DEVELOPMENT REVIEW BOARD
TRANSPORTATION DEVELOPMENT

DRB Project Number: 1003445
Fountain Hills Plaza Tract G-
Dental Office – Building 4

SUBJECT: Site Plan for Building Permit

Project Name: Smiles For Kids Building 3 – Fountain Hills Plaza, Tract G

PROJECT Smiles For Kids - Building 4 Shell  
 4011 Paseo Del Norte N.W.  
 Albuquerque, NM 87114  
 TITLE Site Development Plan for Building Permit  
 SHEET A001

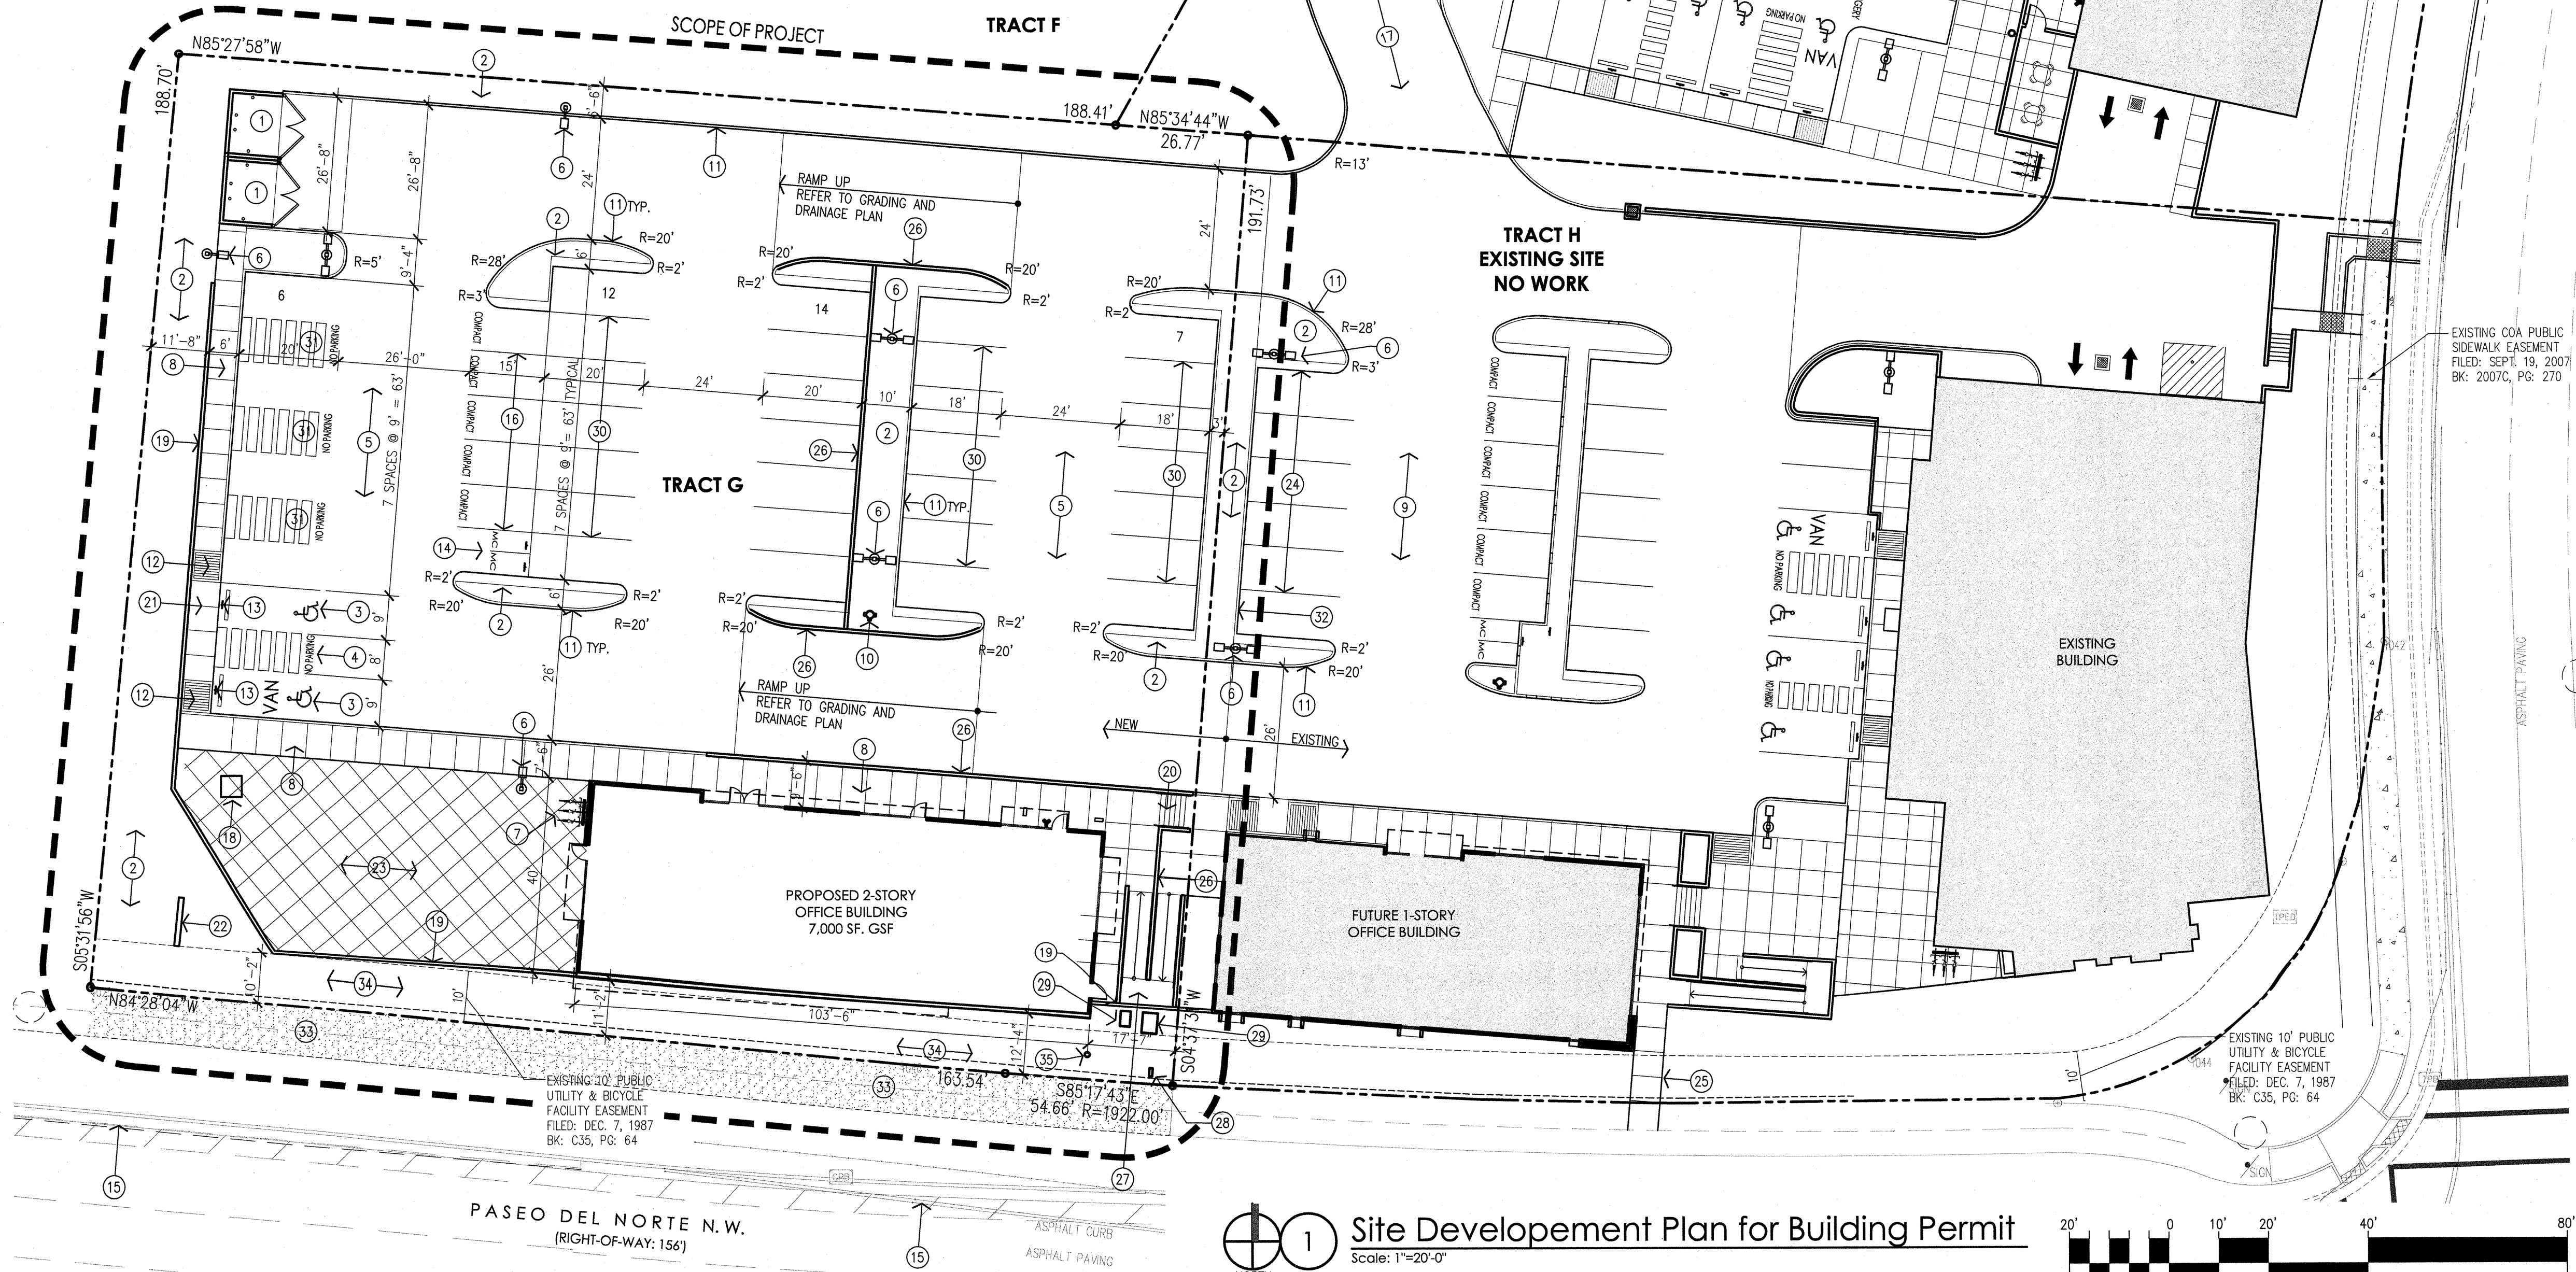
1. Provide access easement and cross access and parking easement for tract G.
2. Parking spaces cannot cross over lot lines.
3. ADA parking on site plan and detail have different dimensions. Please clarify which dimensions should be used.
4. The ADA accessible parking sign must have the required language per 66-7-352.4C NMSA 1978 "Violators Are Subject to a Fine and/or Towing." Please call out detail and location of HC signs.
5. The first parking aisle is labeled 58' wide but is scaled at 24'. Please review the plans for typos.
6. Site plan and grading plan do not match. For example there are 4 ADA parking spaces on the grading plan, and only 2 on the site plan.
7. The patio appears to be pretty steep. If it is expected to be accessible, the grading should be adjusted.
8. Show trail along Paseo del Norte.

1. The office use to be added by Administrative Amendment was approved on 3/2/18.
2. It appears the motorcycle spaces were counted toward the total parking, so the total should be 42 with 5 compact instead of 6.

3. The Site Plan for Subdivision (SPS) Design Standards includes a maximum parking allowance of required plus 10%, so the site is over-parked.
4. Is the eastern lot line planned to be adjusted to better align with the parking stalls?

8. The SPS only allows for 4 total monument signs for the development. The proposed monument sign is the last one allowed for Fountain Hills Plaza.
9. The proposed fire hydrant is located in different spots on A001 and C200.

PROJECT  
Smiles For Kids - West Site  
9211 Eagle Ranch Road NW  
Albuquerque, NM 87114  
TITLE  
DRAINAGE MANAGEMENT PLAN

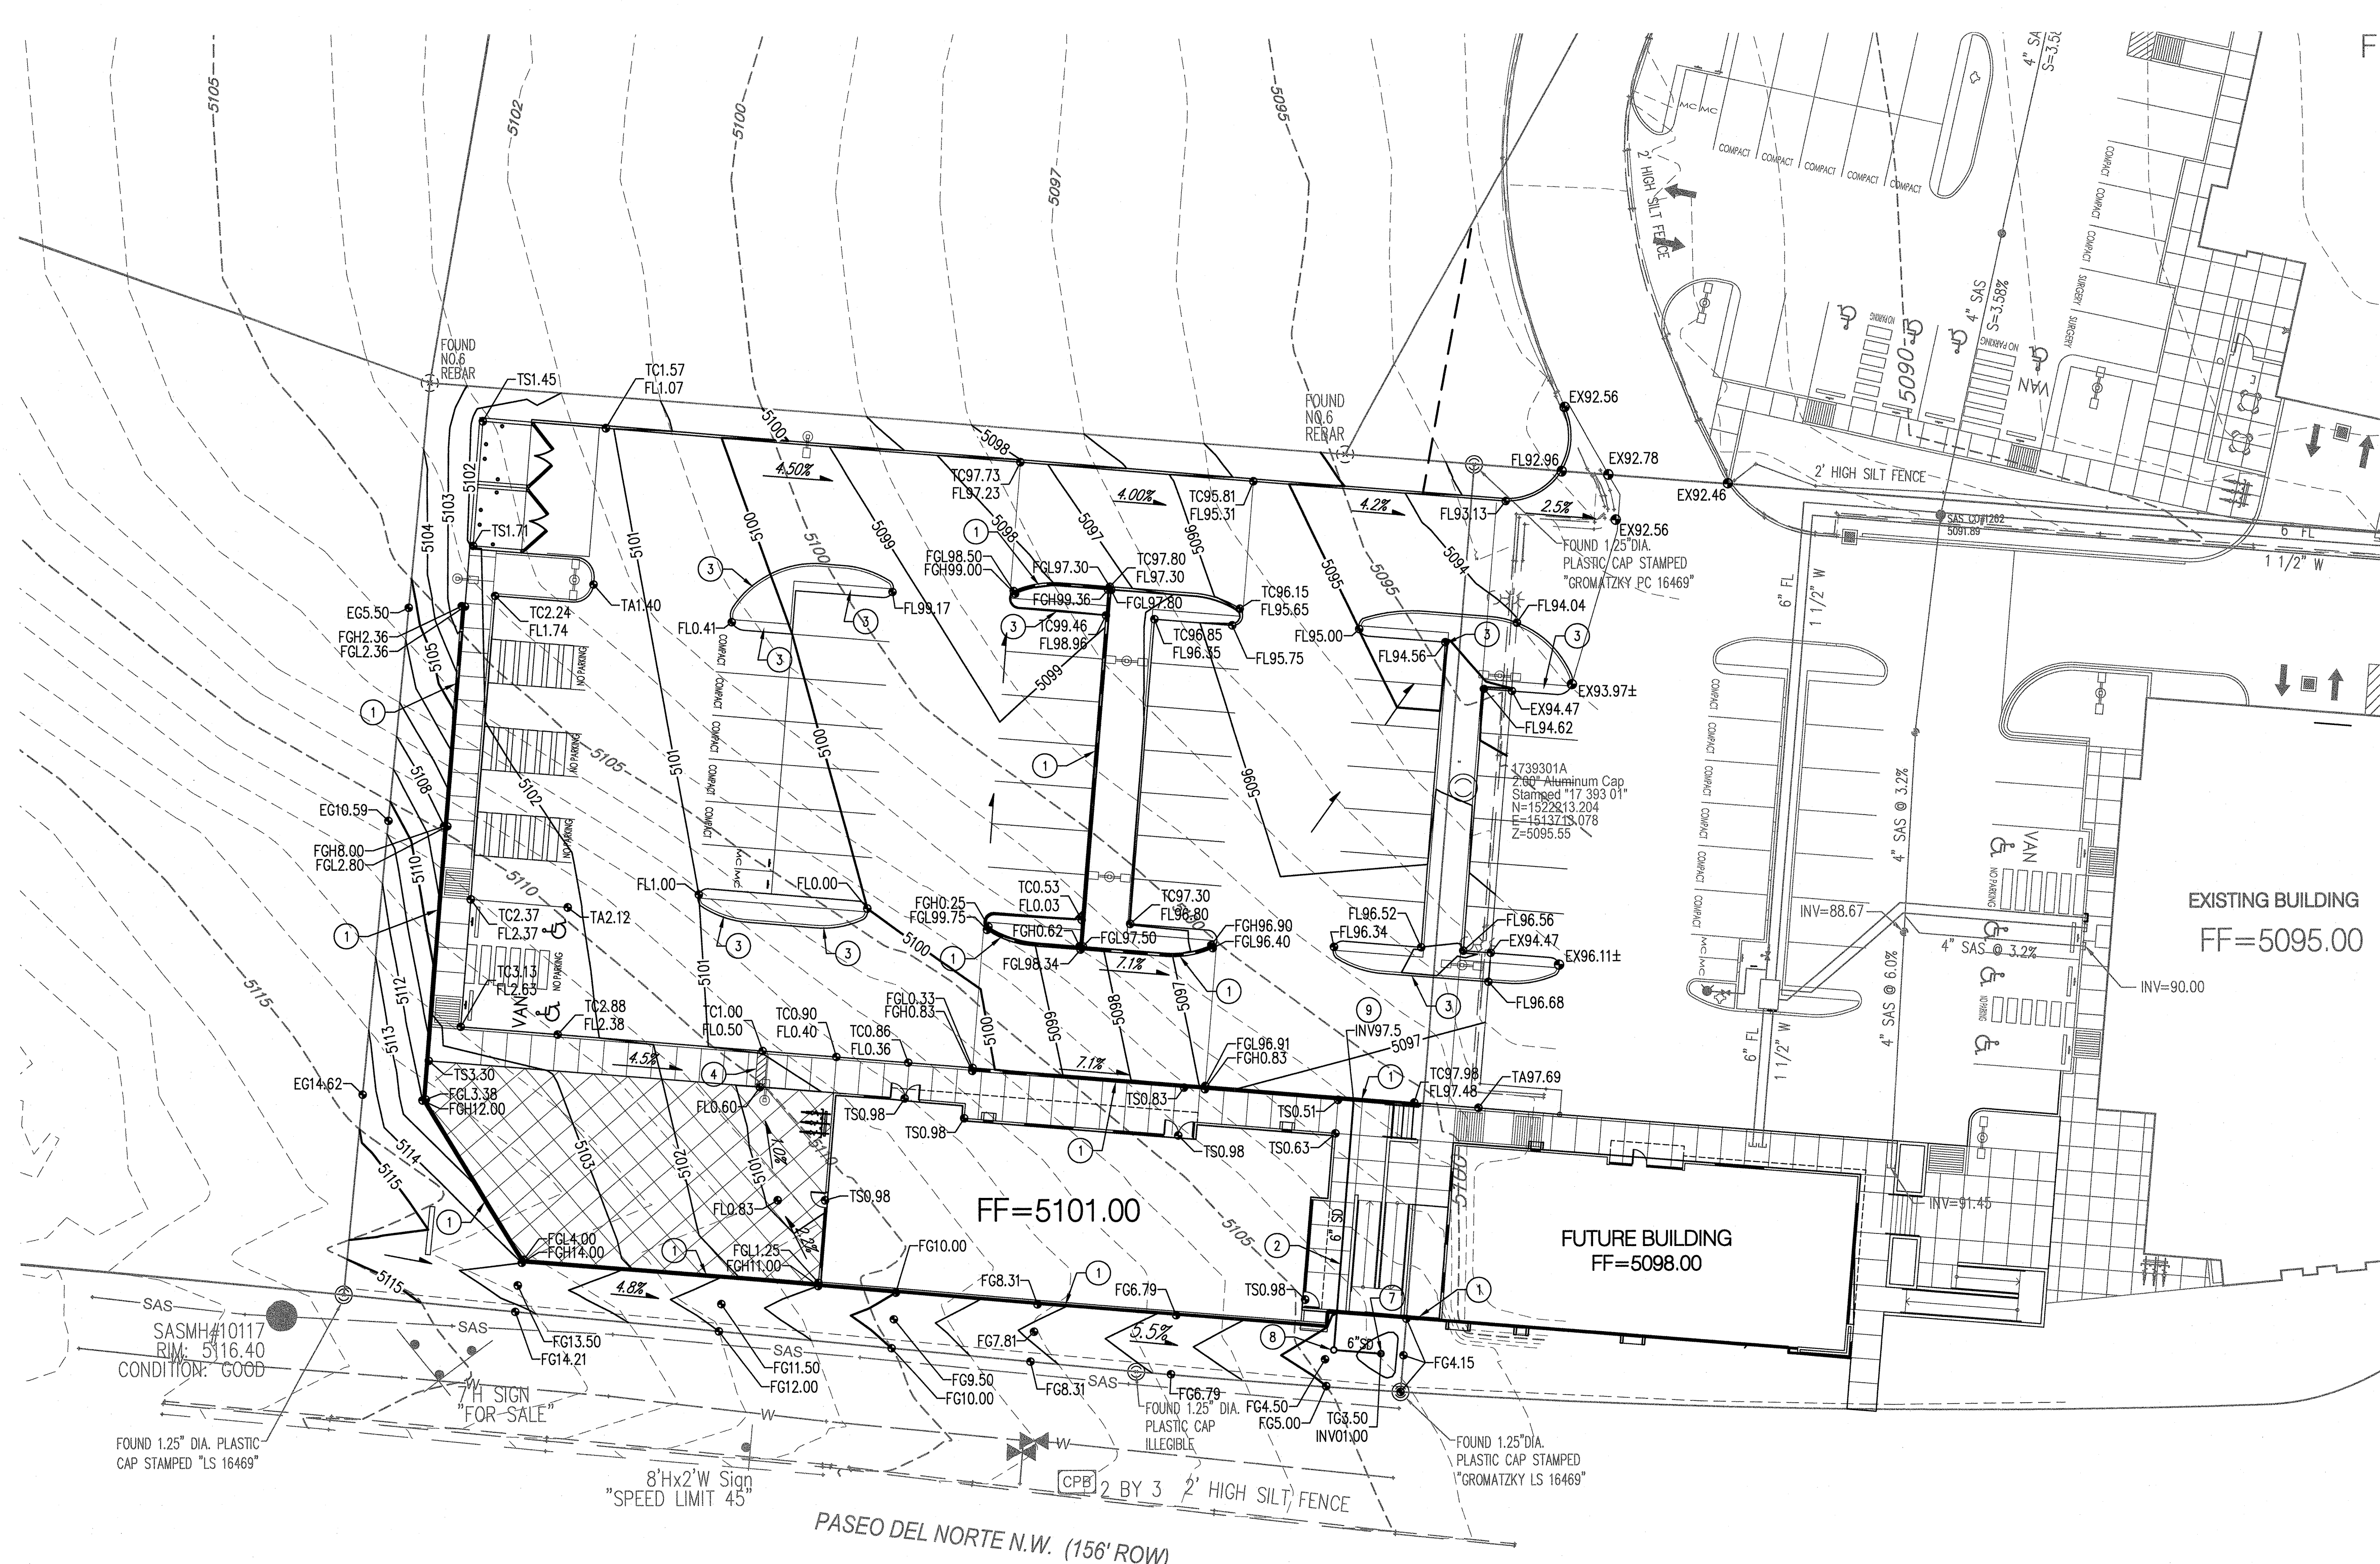
- Hydrology has pulled its approval of the Conceptual Grading and Drainage Plan based on the existing HGL of the existing detention pond and storm sewer system.
- Hydrology cannot sign the SPBP.

2 East Elevation  
Scale: 1/4"=1'-0"

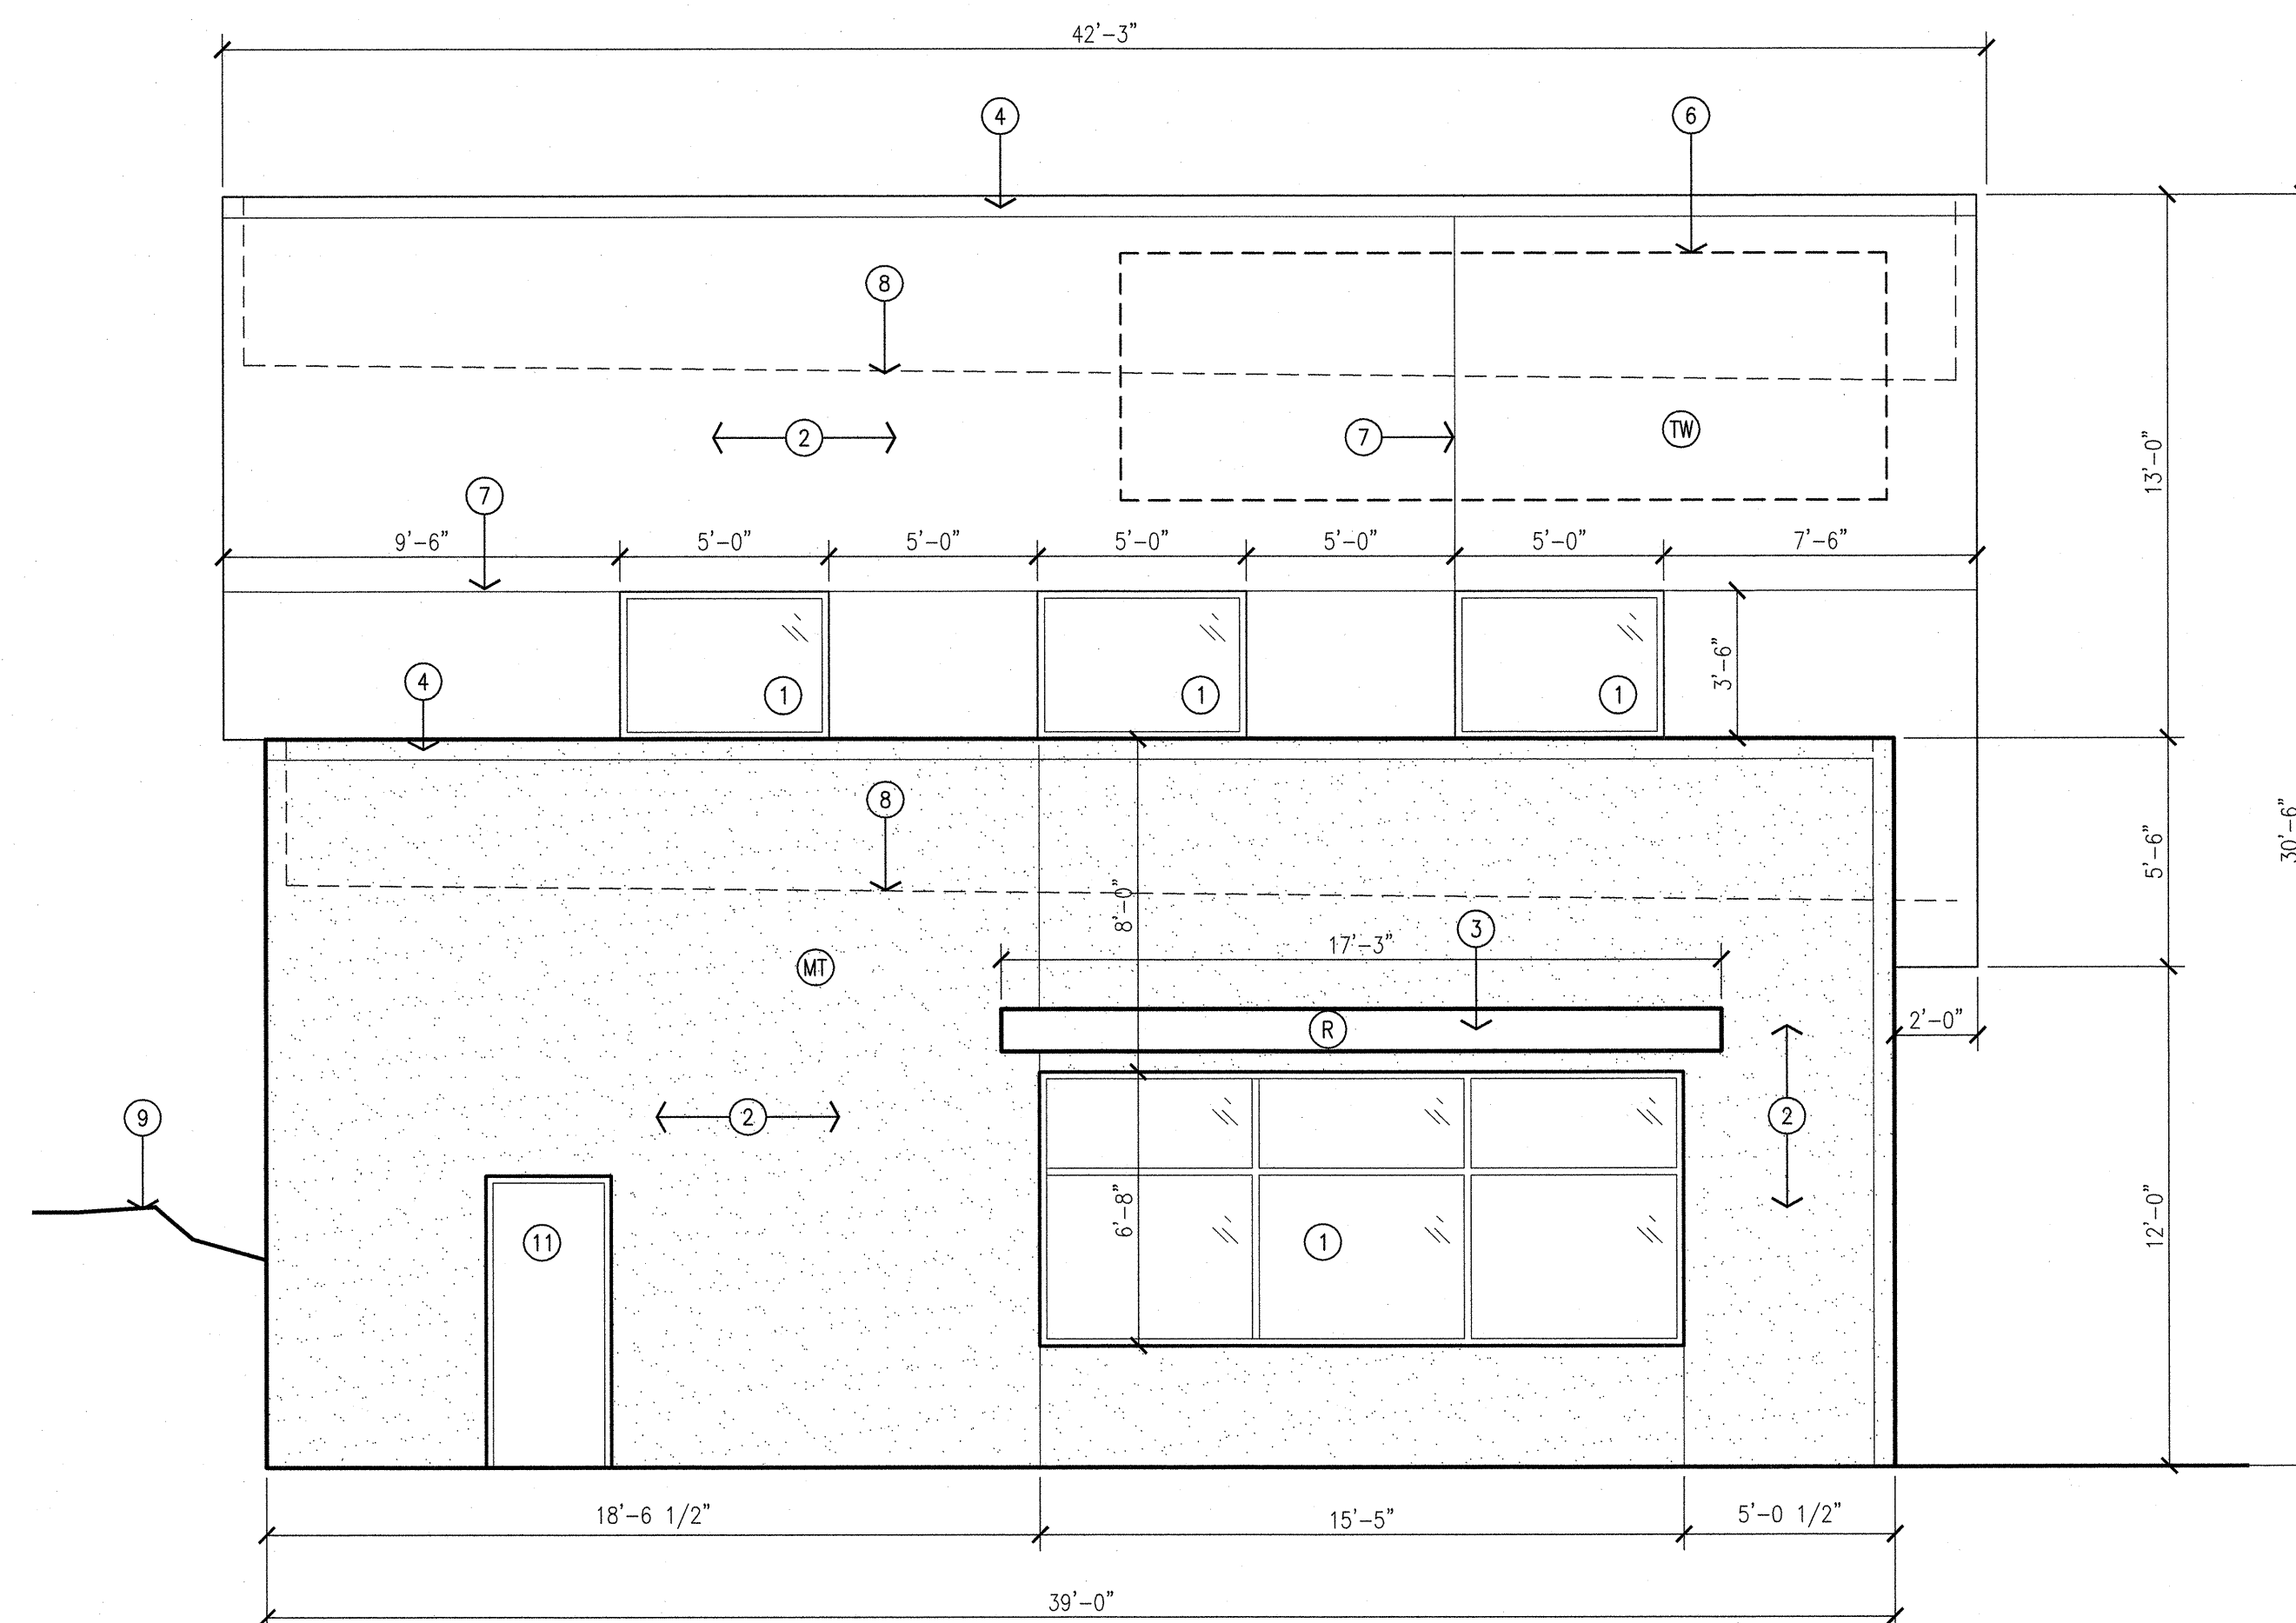
12. Keynote 16 is shown on what appears to be a door or window on the east elevation – should it instead be Keynote 1?
13. Where do the building-mounted sign calculations/maximums come from? I did not see anything other than the Zoning Code requirements that would typically allow a bit more, so you may not want to unnecessarily limit yourself for potential changes later on.
